Your Ref: OWPC15199
Our Ref: BR/194/17/PL 30-06-2017
Please ask for:
Richard Temple

Demolition of the existing Foreshore office & decommissioning of existing underground toilets. New purpose built unisex toilet block including urinals, baby changing facilities & accessible WC, plus a separate beach office with public information point & first aid facilities. All located on the existing seafront promenade.

Promenade Opposite Clarence Road The Esplanade Bognor Regis

Thank you for your internet representation made on 11th August 2017 which has been recorded as '**an objection**' with the comments as follows:

DRAWING
Proposed Toilet Elevations

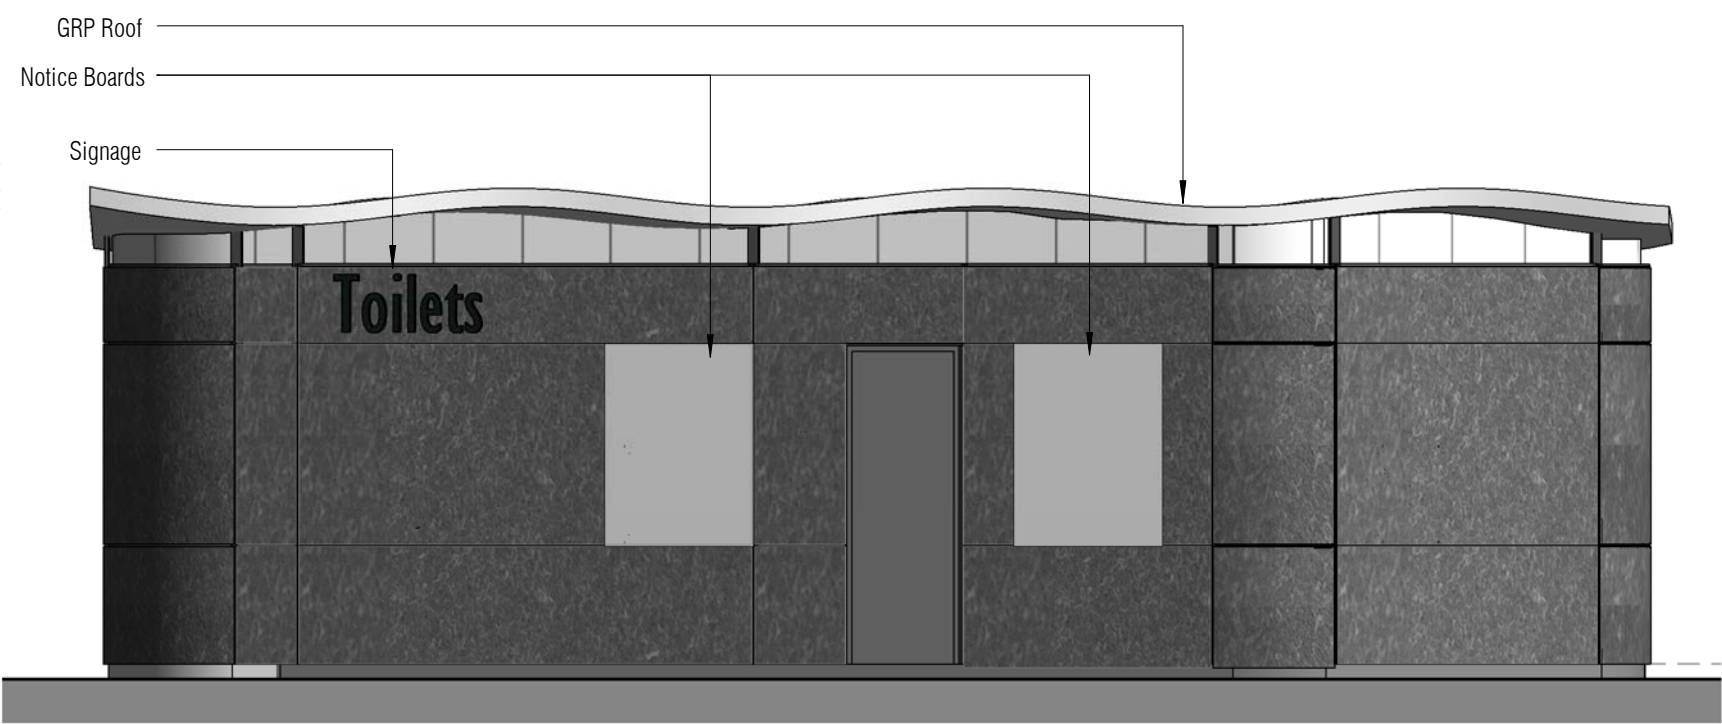
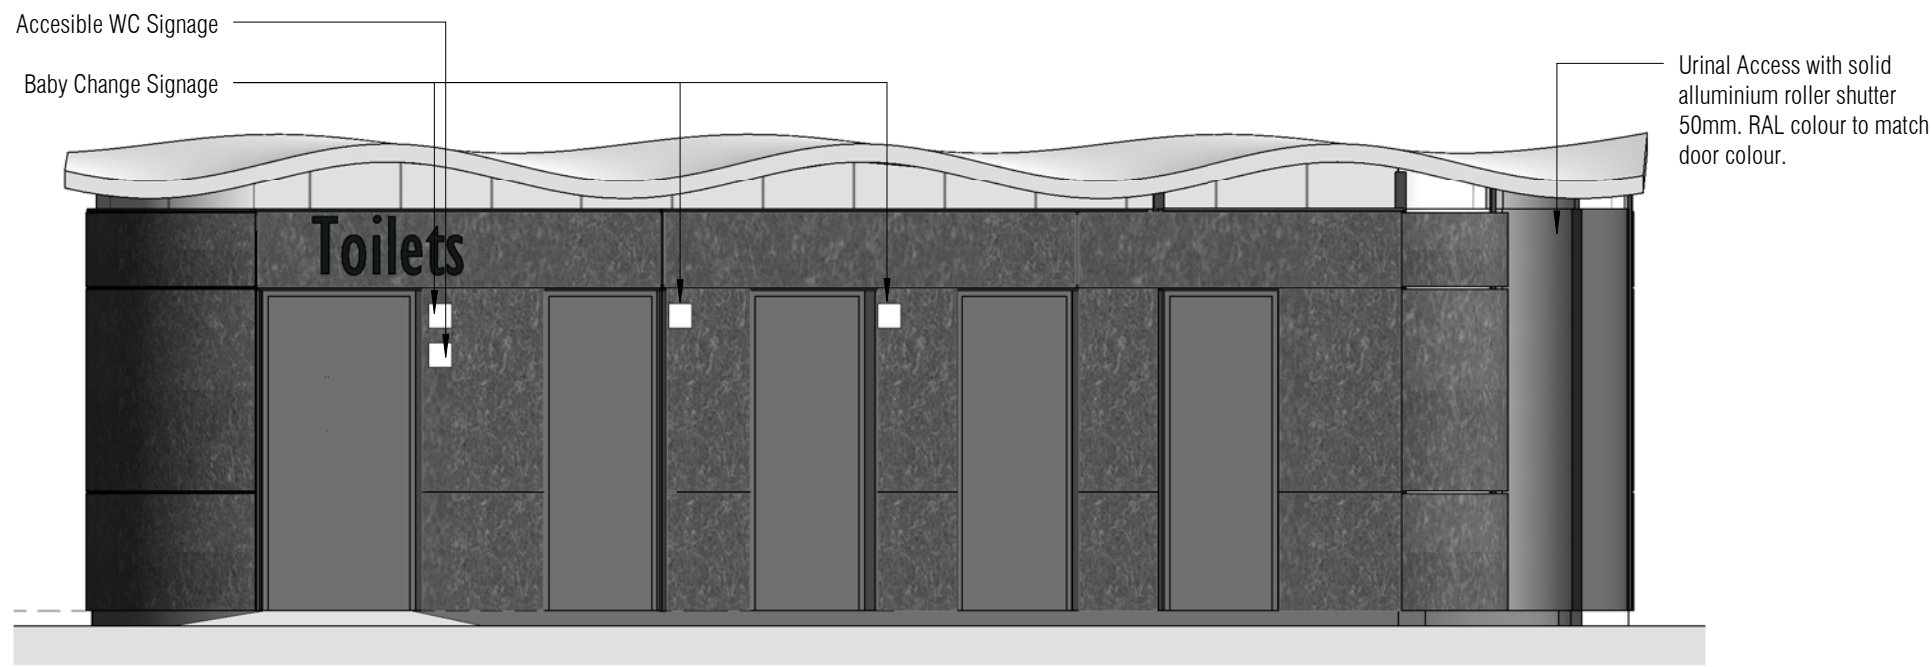
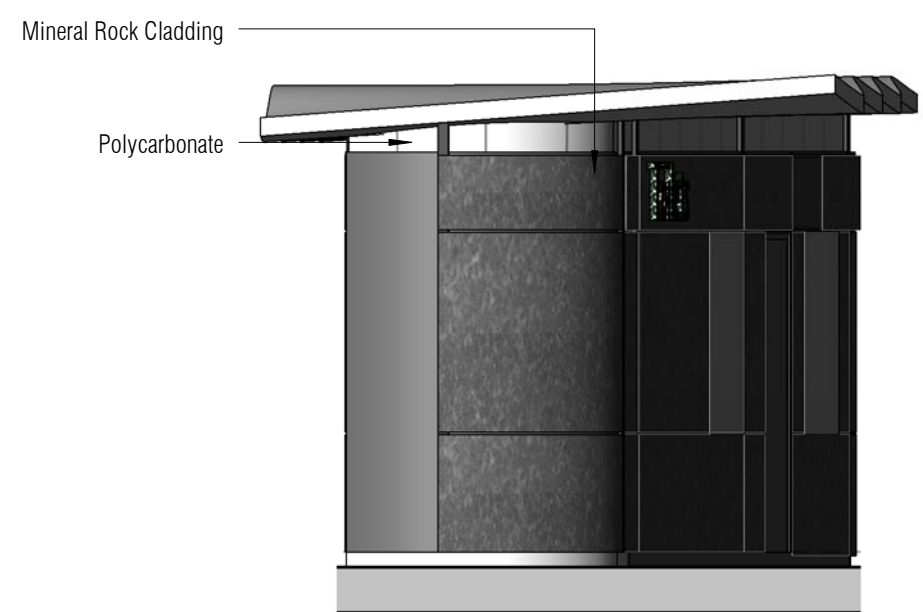
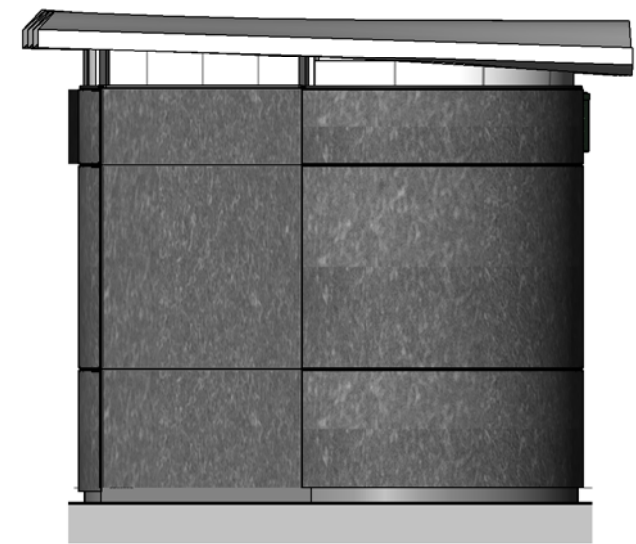
All the doors to the five cubicles plus the urinal at the west end are on the north side of the block so are facing & immediately opposite the Esplanade Grande flats (not opposite Clarence Road as mentioned in the application)

The impact of this block is detrimental for all the residents of Esplanade Grande particularly for those on the lower floors. The loss of privacy, being overlooked by those waiting & leaving the cubicles, the noise created by the coming & going with doors being opened & shut will add further nuisance & disturbance to those living opposite. Noise, nuisance & disturbance are all valid reasons for objecting.

The proposed toilet block is also longer on the west side than the present Foreshore Office and as we already have a concession, namely the Coffee Cup, in front of Esplanade Grande I think it is unfair, inconsiderate & disrespectful for this application to be approved. I recognise the importance of this amenity, particularly for visitors, but the needs of residents also have to be considered.
